10 May 2017

Mitchell Isaacs
Director, Planning Policy & Assessment Advice
Department of Primary Industries

Re: Western Sydney Stadium - Response to Stage 2 DA Comments

EARTHWORKS PLAN

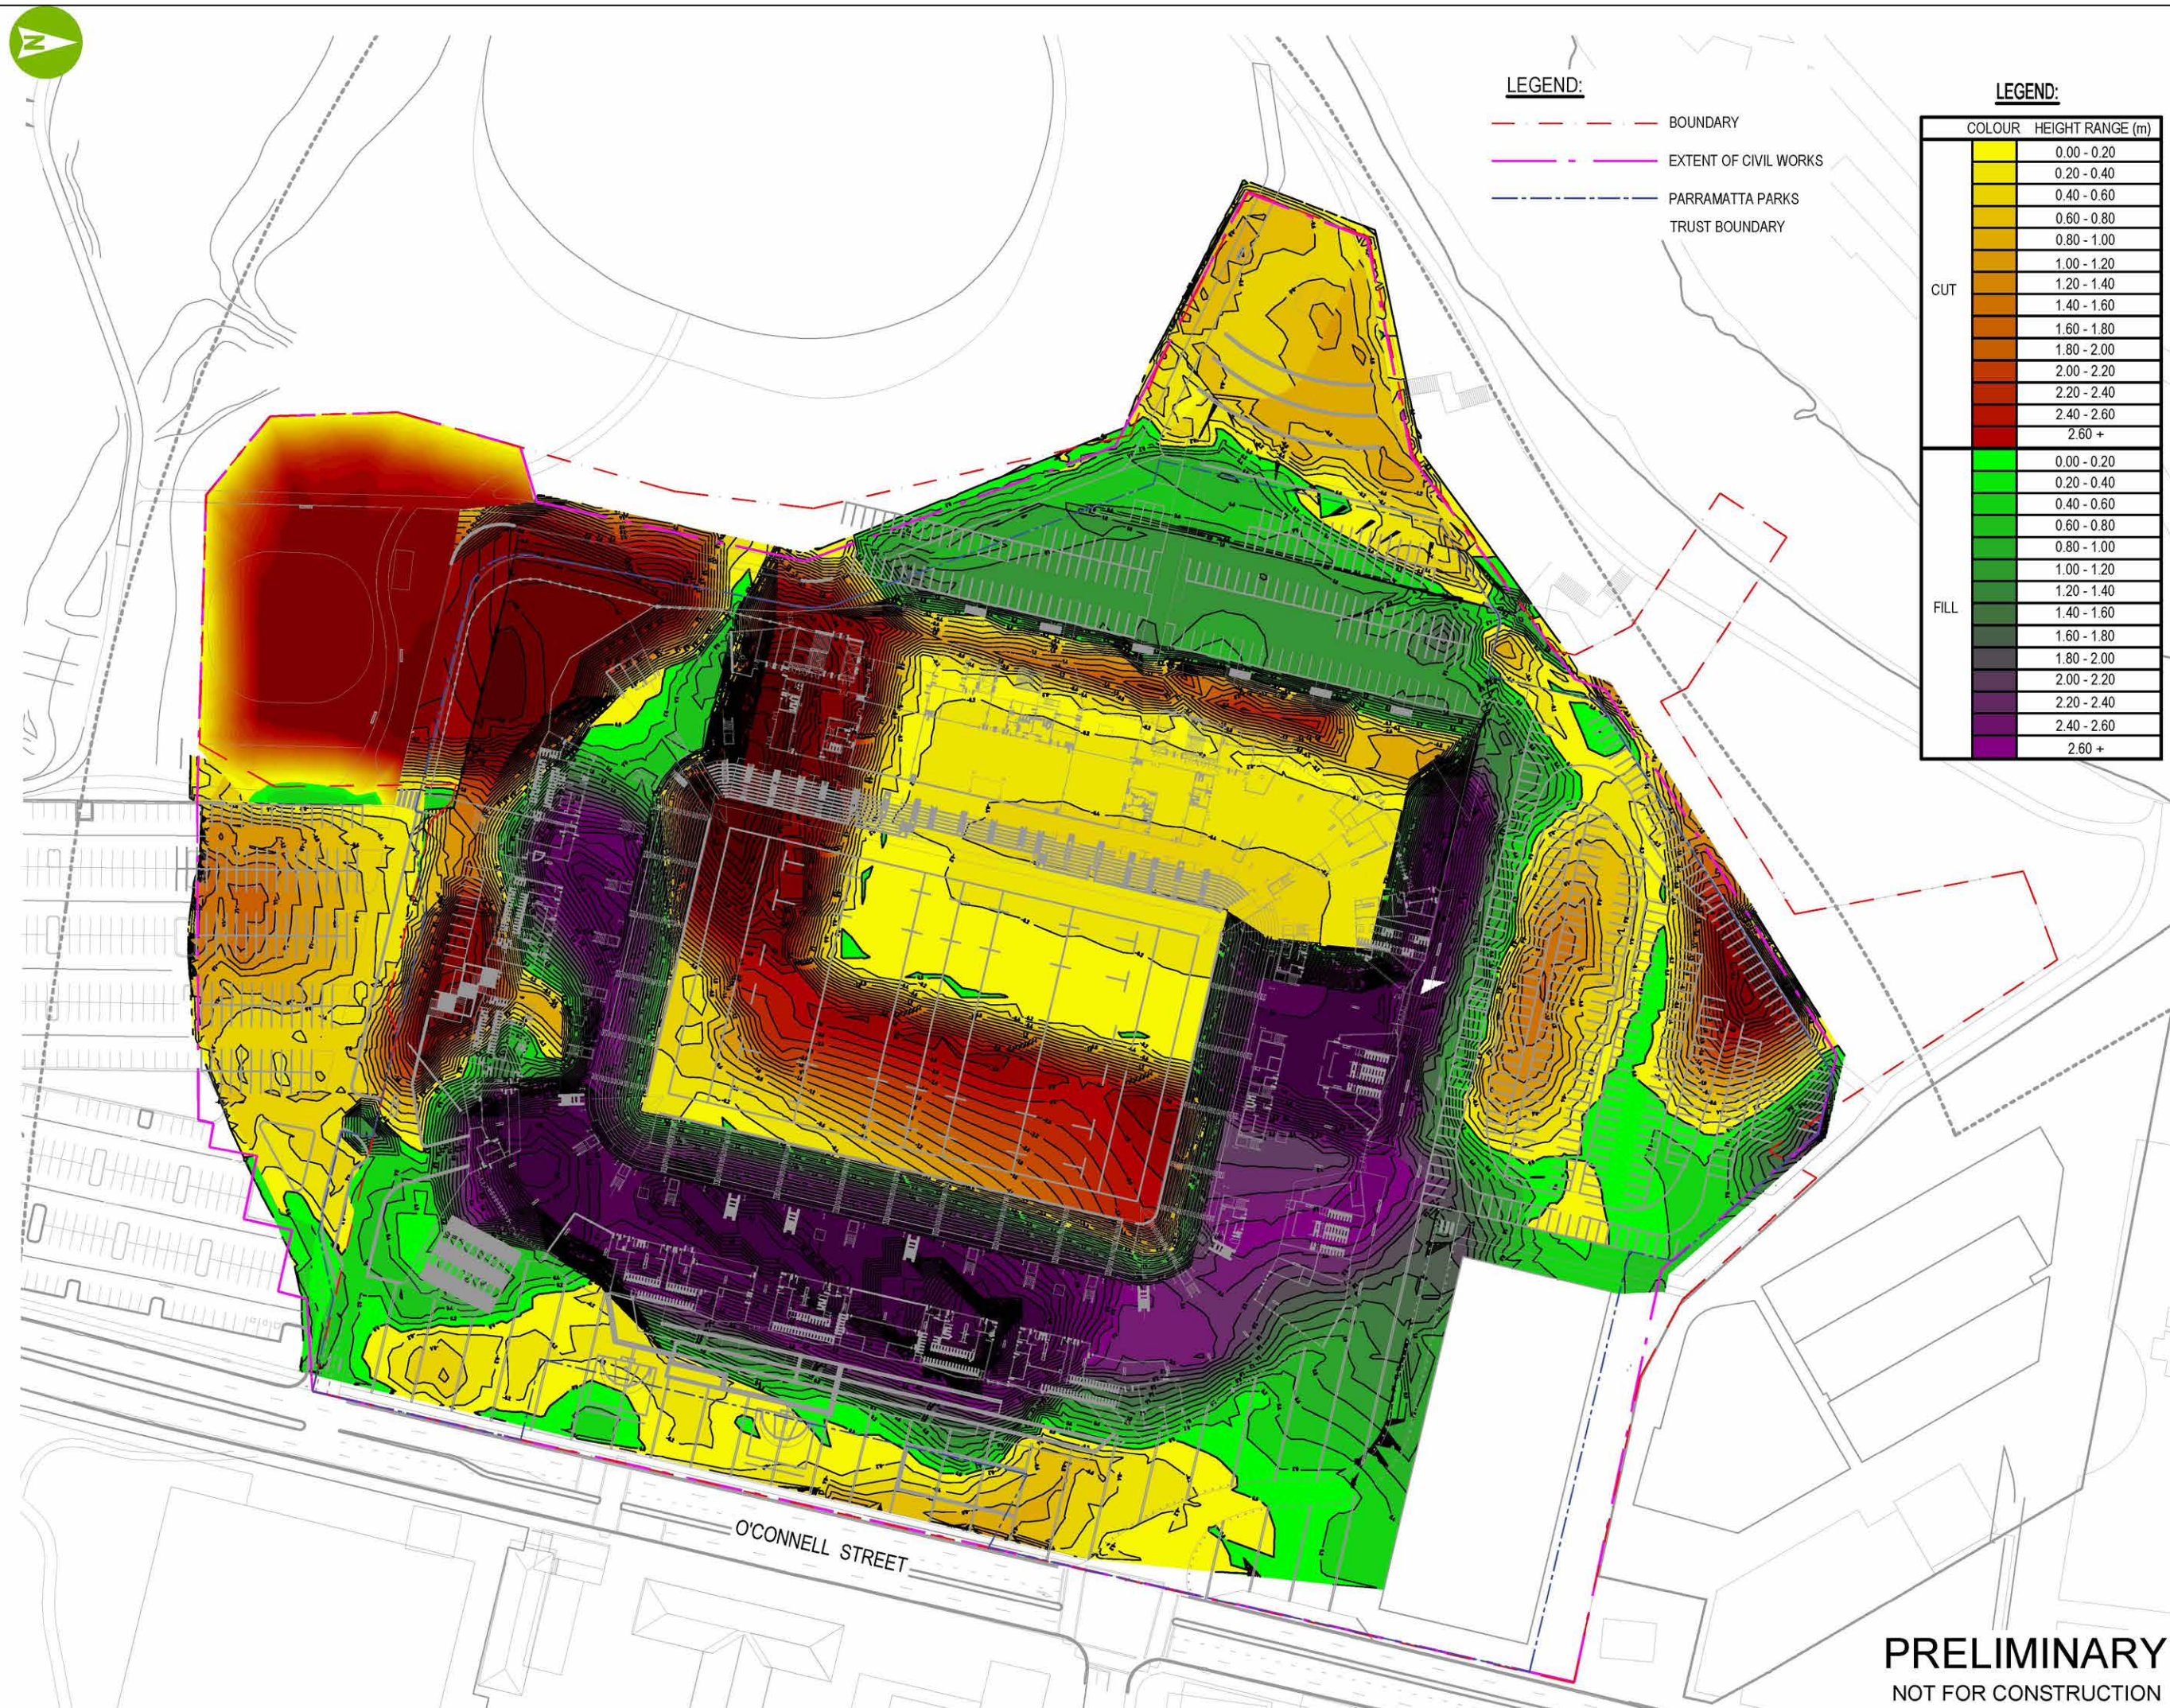
- ***Where reasonable and feasible, the siting of the development should be located outside the riparian corridor within the subject site. Should nonriparian uses encroach into the outer 20m wide riparian area, an equivalent riparian offset area should be provided within the site which is connected to the riparian corridor;***

However, the City of Parramatta Council has indicated that a wider 40m riparian buffer is required,

“The Parramatta River forms the western boundary of the site and is a 4th Order Watercourse (Strahler stream ordering system) requiring a minimum 40m vegetated riparian zone (VRZ) from the ‘top of bank’ in accordance with the NSW Office of Water ‘Guidelines for riparian corridors’.”

Clarity is sought on whether a 20m or 40m riparian buffer is appropriate in this situation.

The 20m wide riparian buffer and its location in relation to the site works is shown in the diagram below.

The encroachment and equivalent offset areas are located and calculated as follows, and is also shown in the diagram below.

-  - Riparian zone conflict with site works area – 13.7m²
-  - Riparian zone conflict with works outside of site area – 198m²
-  - Riparian offset area – 215m²

A 40m wide riparian buffer has been identified, and the associated encroachments and offsets calculated. A vegetation offset area has been identified which is,

- located within the Western Sydney Stadium site boundary,
- set away from activity areas,
- adjacent to, and part of a steep embankment with existing native forest,
- connected to the riparian corridor.

- Riparian zone conflict with site works area – 960 m²
- Riparian zone conflict with works outside of site area – 605m²
- Riparian offset area – 1575m²
